Griffith City Council

**Report for MP 11 0053:
Independent Assessment**

**Griffith Private Hospital and
Teaching and Learning Centre**

May 2012

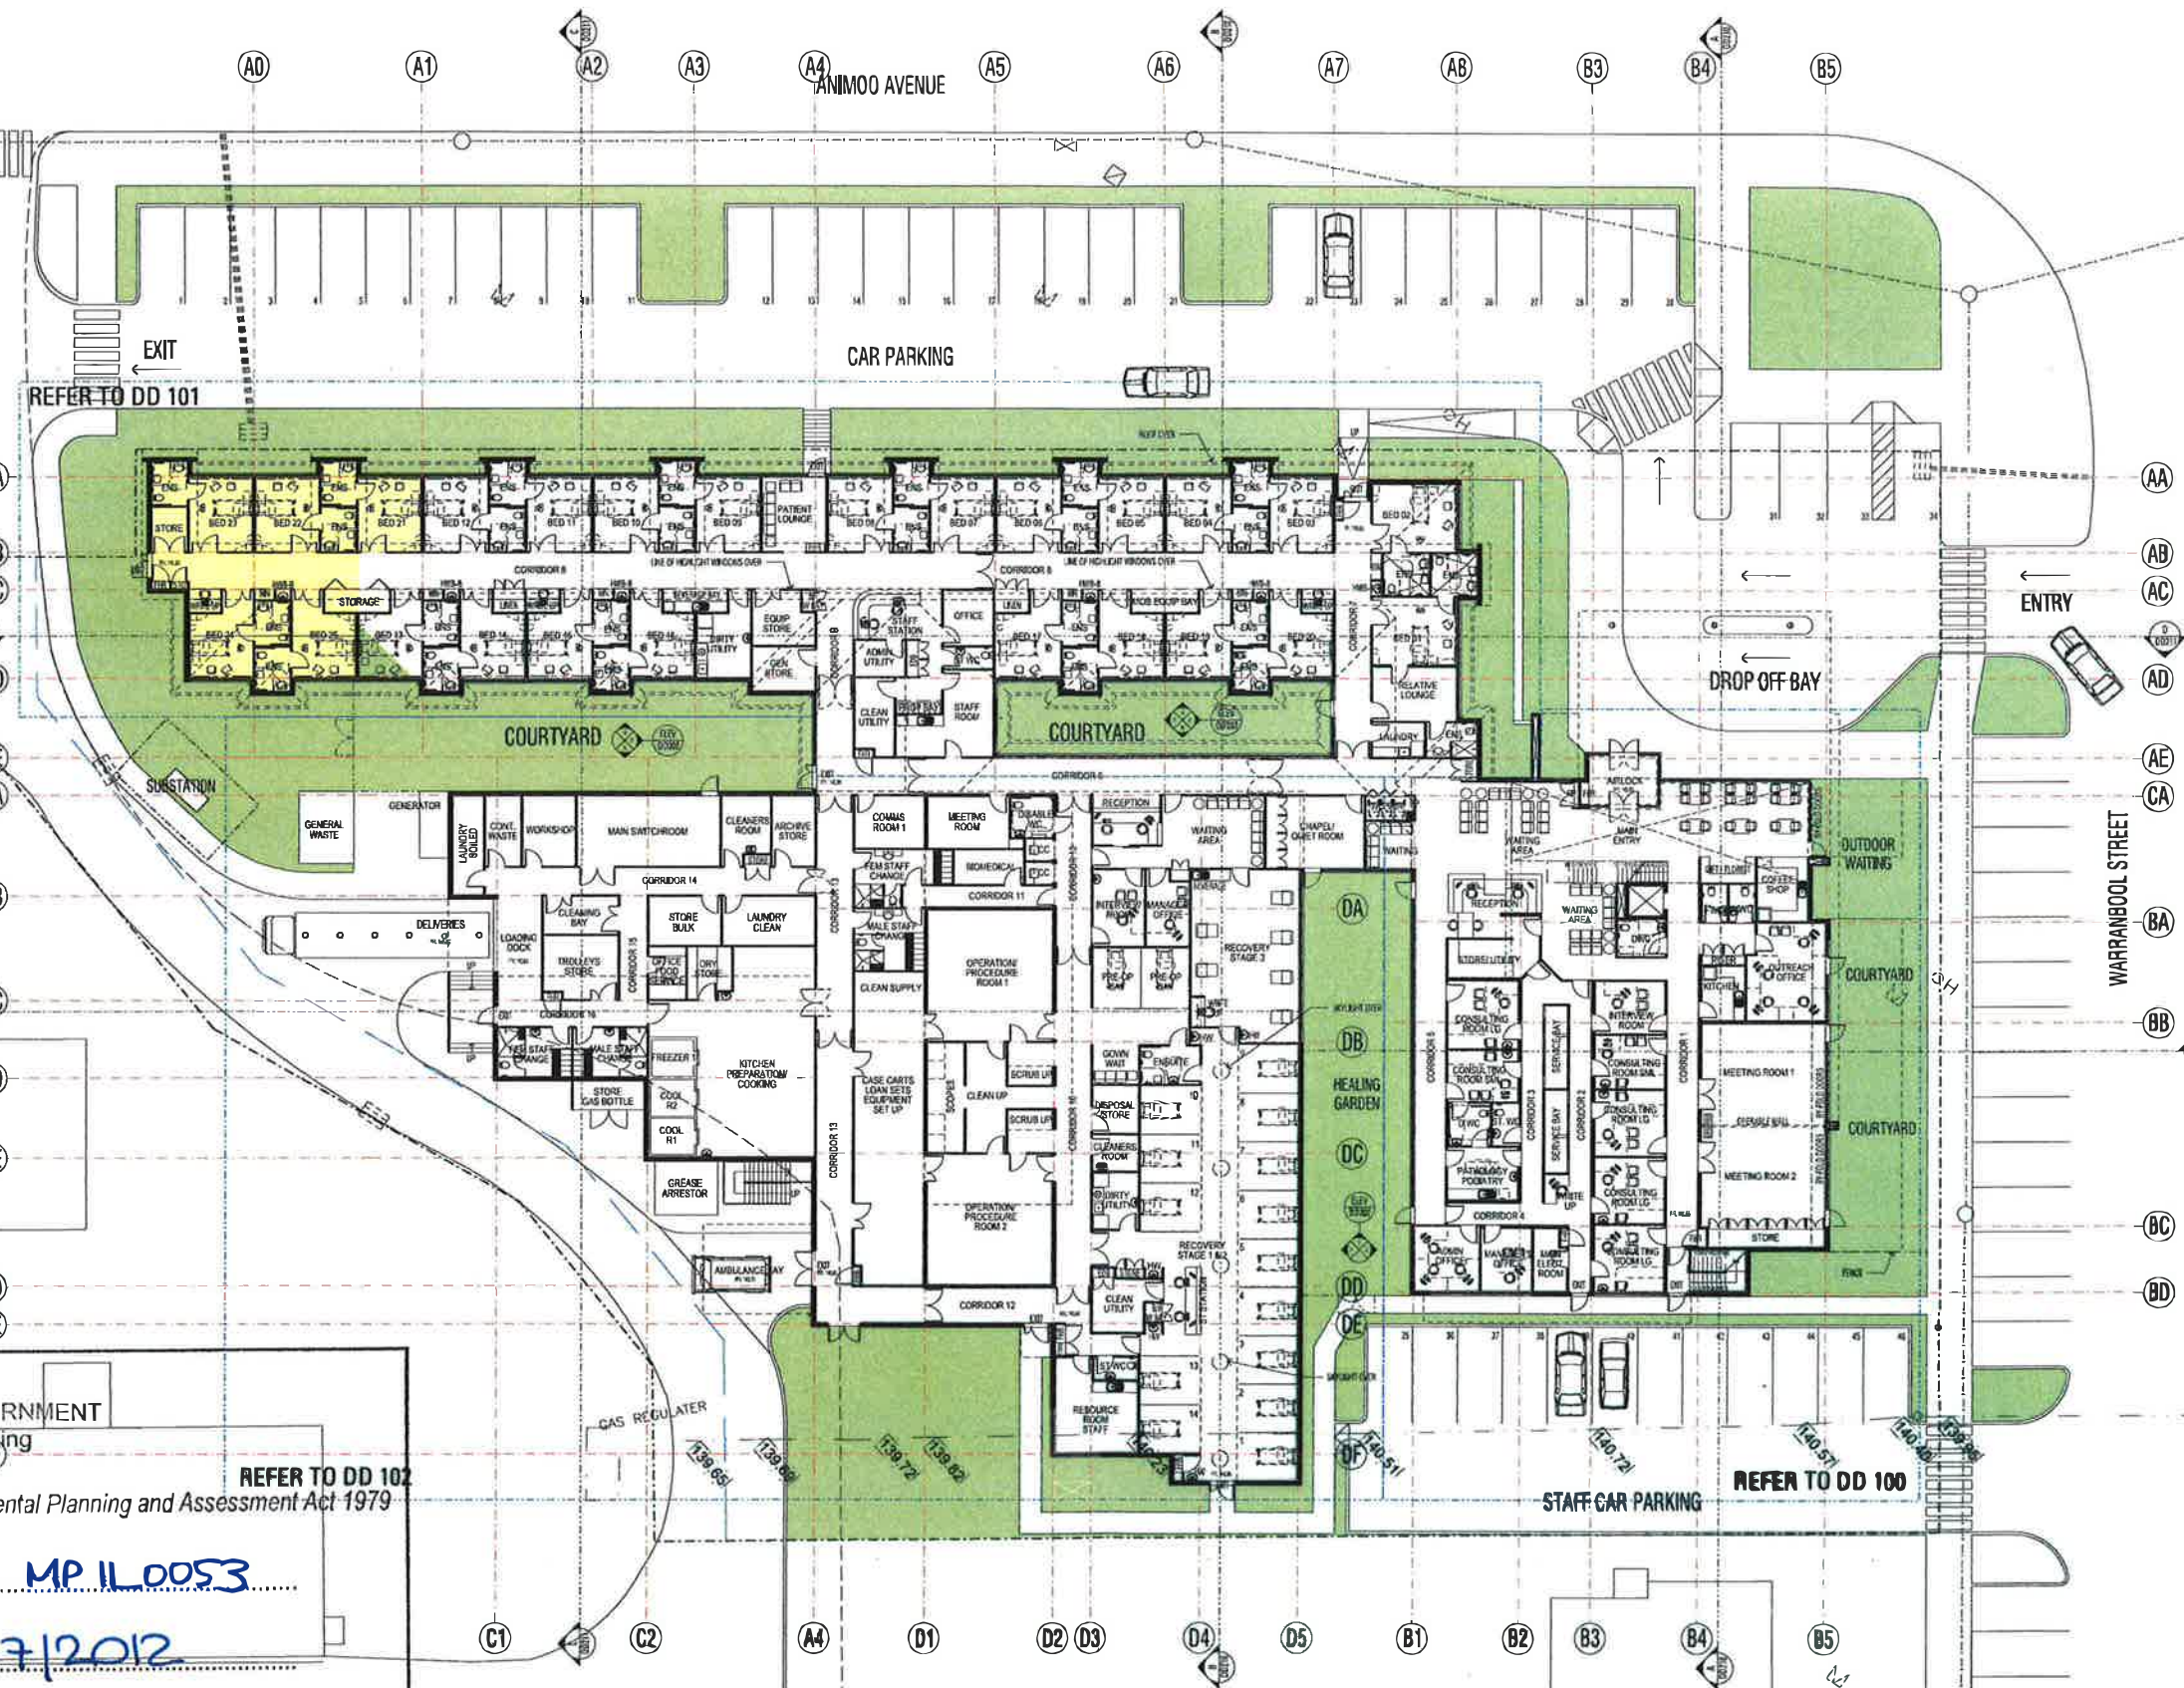
The landscape design (refer drawing DD-005) includes a large tree planted directly over what appears to be an underground electricity service near the corner of Animoo Avenue and Warrambool Street. The landscape design will have to be adjusted to address this clash.
